EAGLE RISING, FILING NO. 1

FINAL DRAINAGE REPORT

AUGUST 2015

SF-18-029

EAGLE RISING HYDROLOGY MAP PROPOSED (ON-SITE)

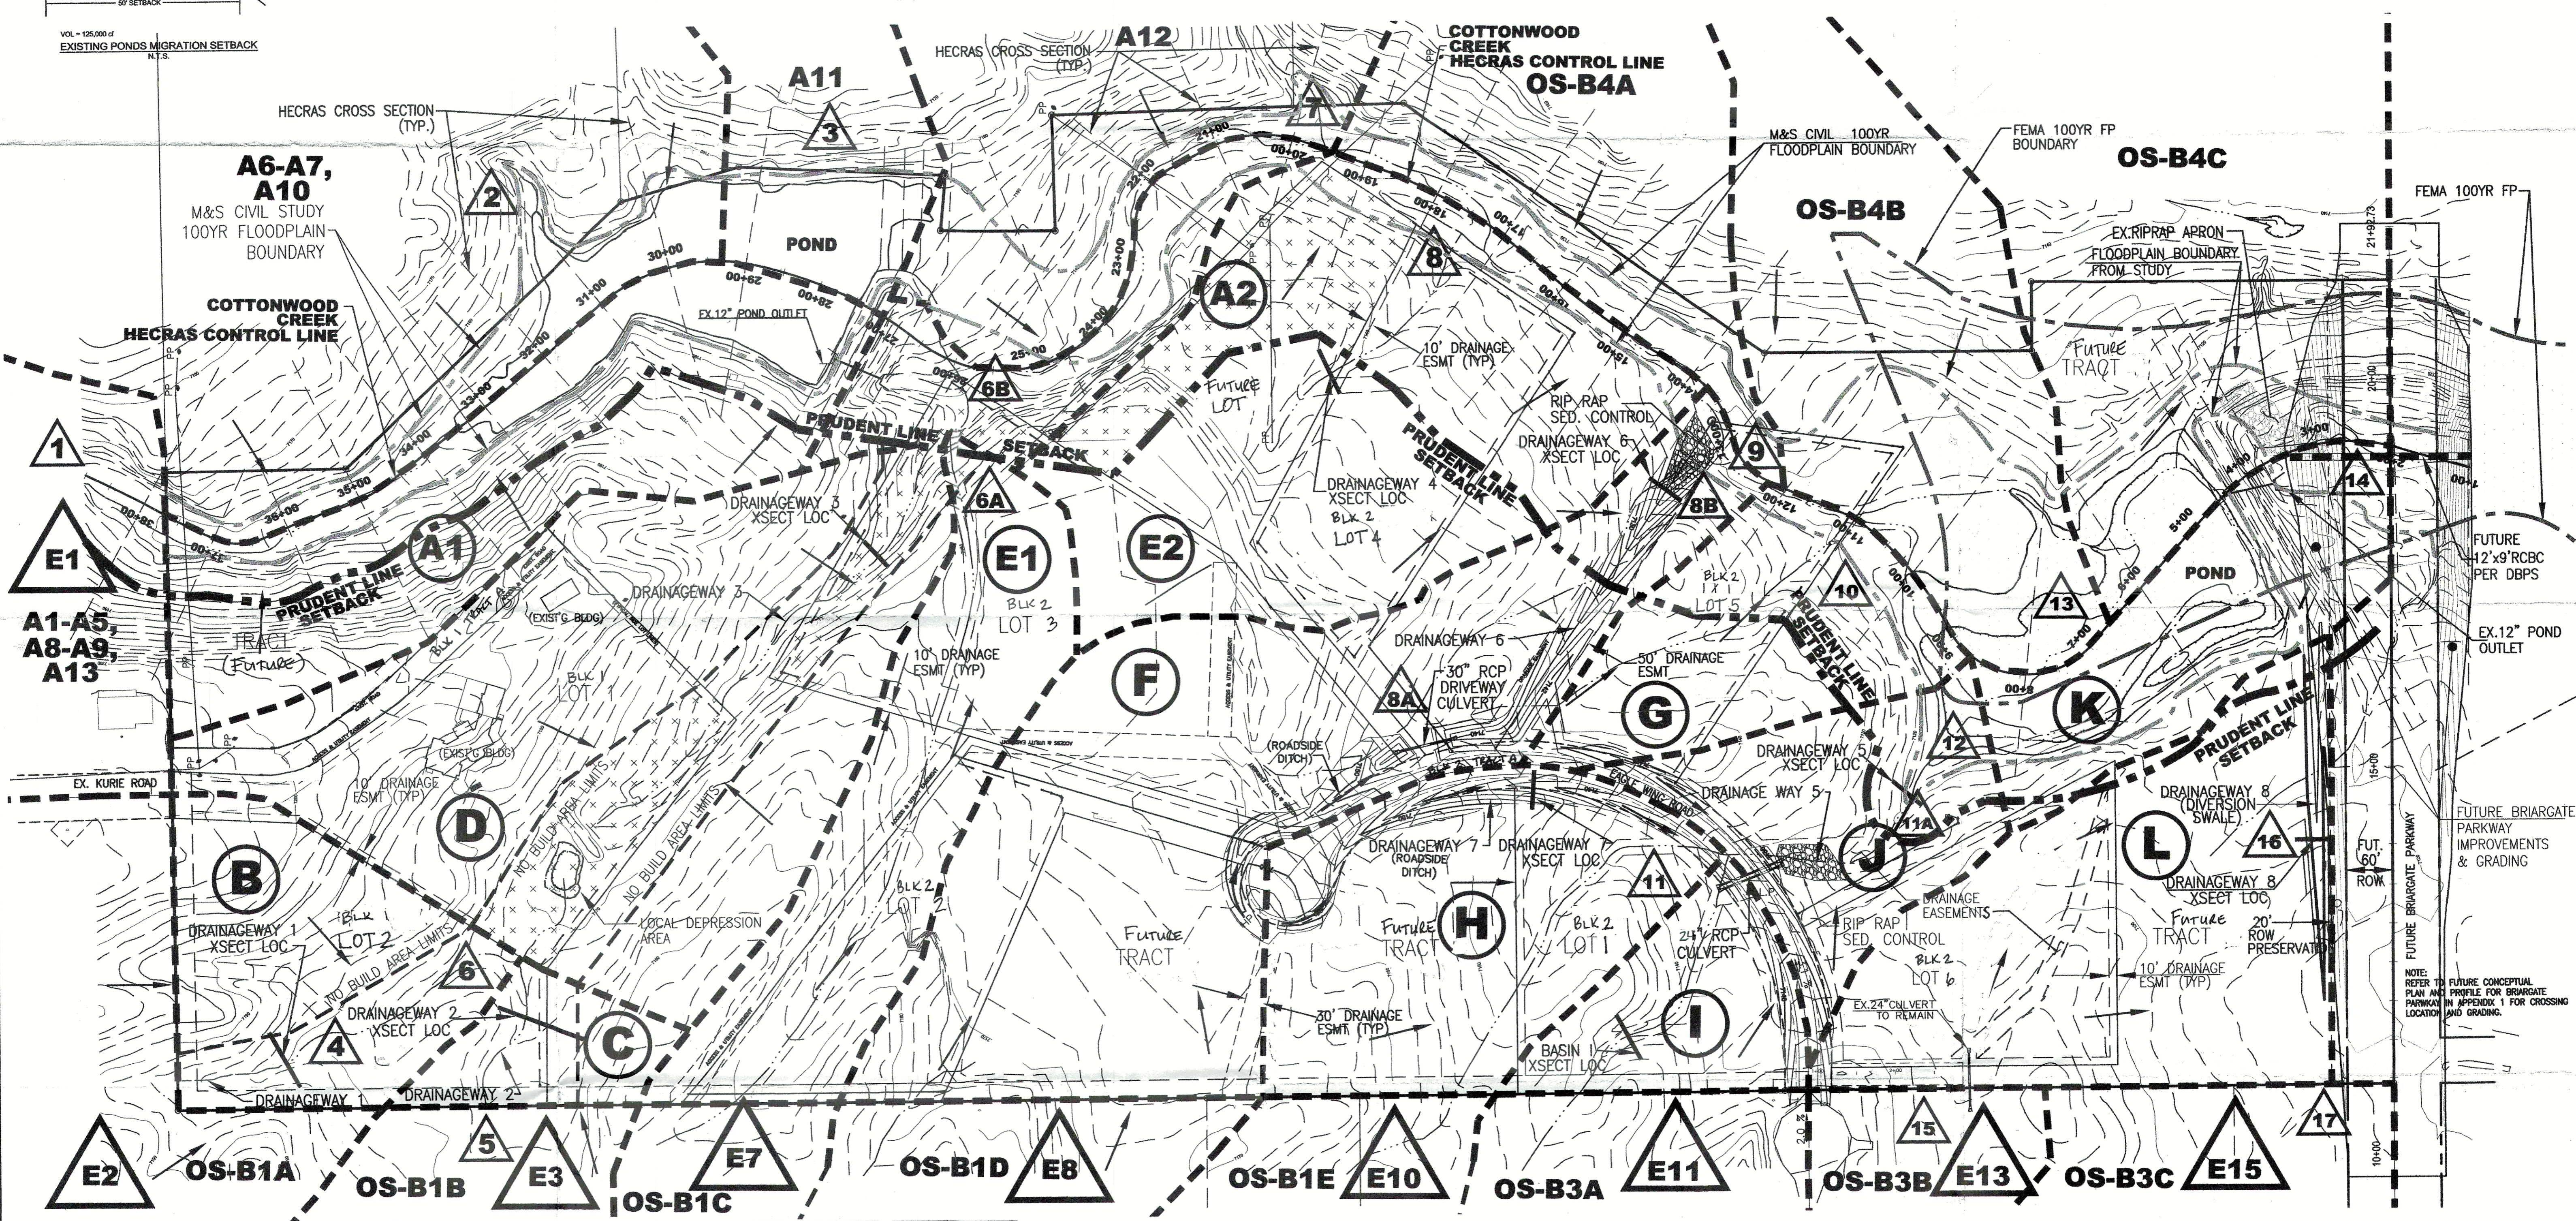
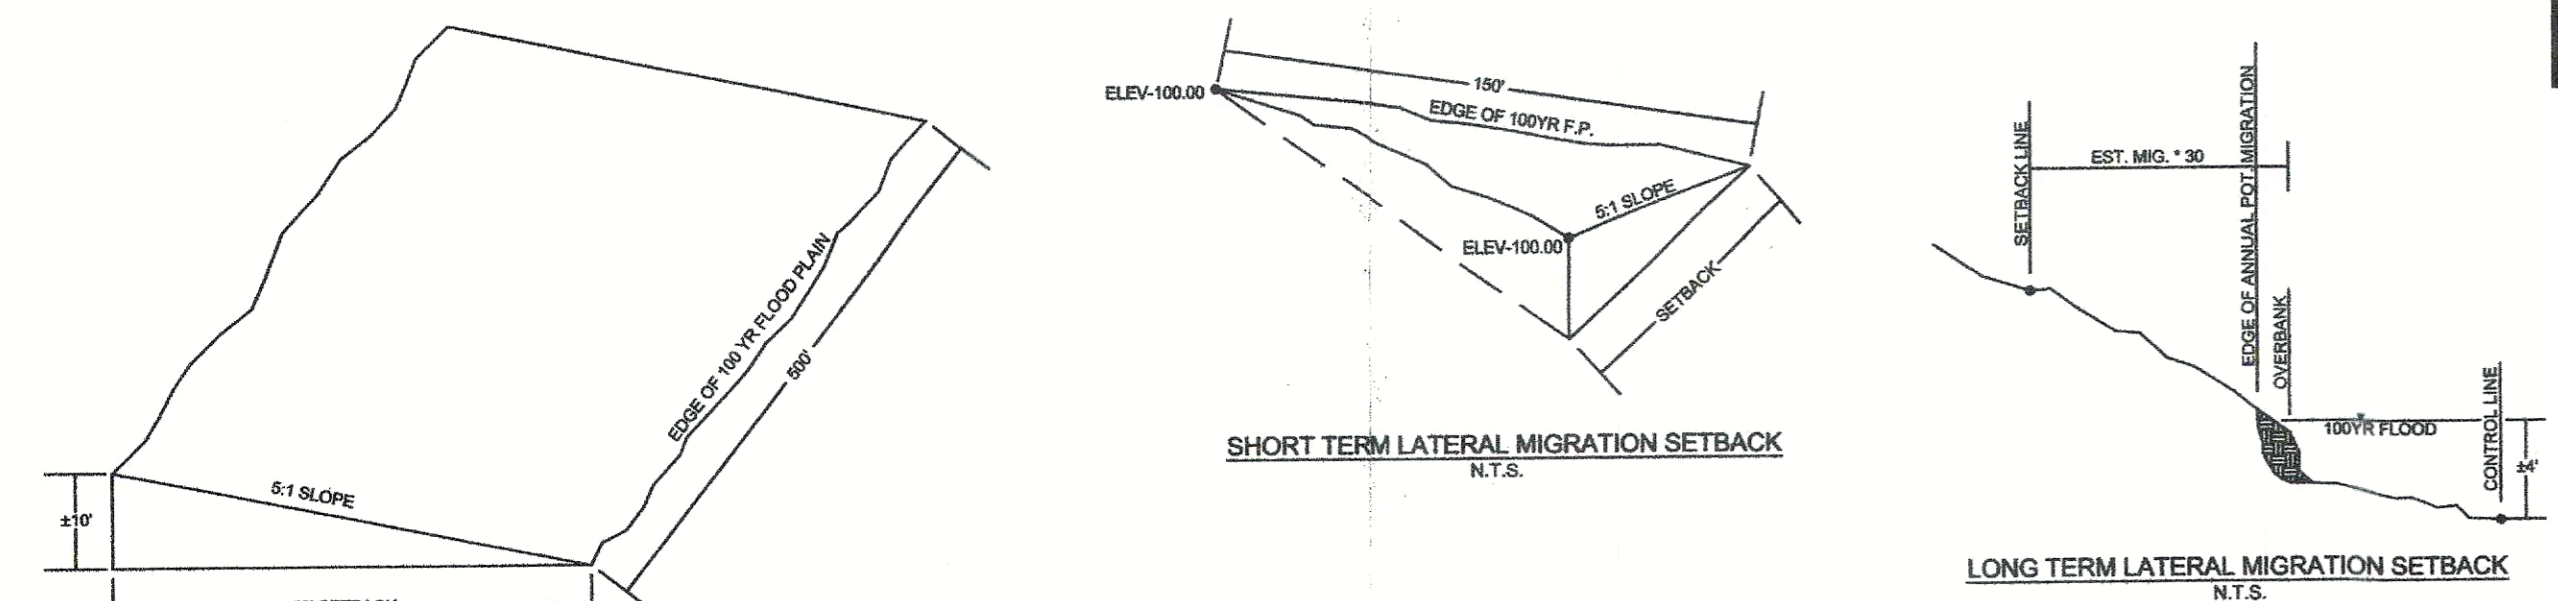
And the proposed roadway area will need SWQCV Treatment.

Channel improvements need to match
County criteria for the proposed velocities
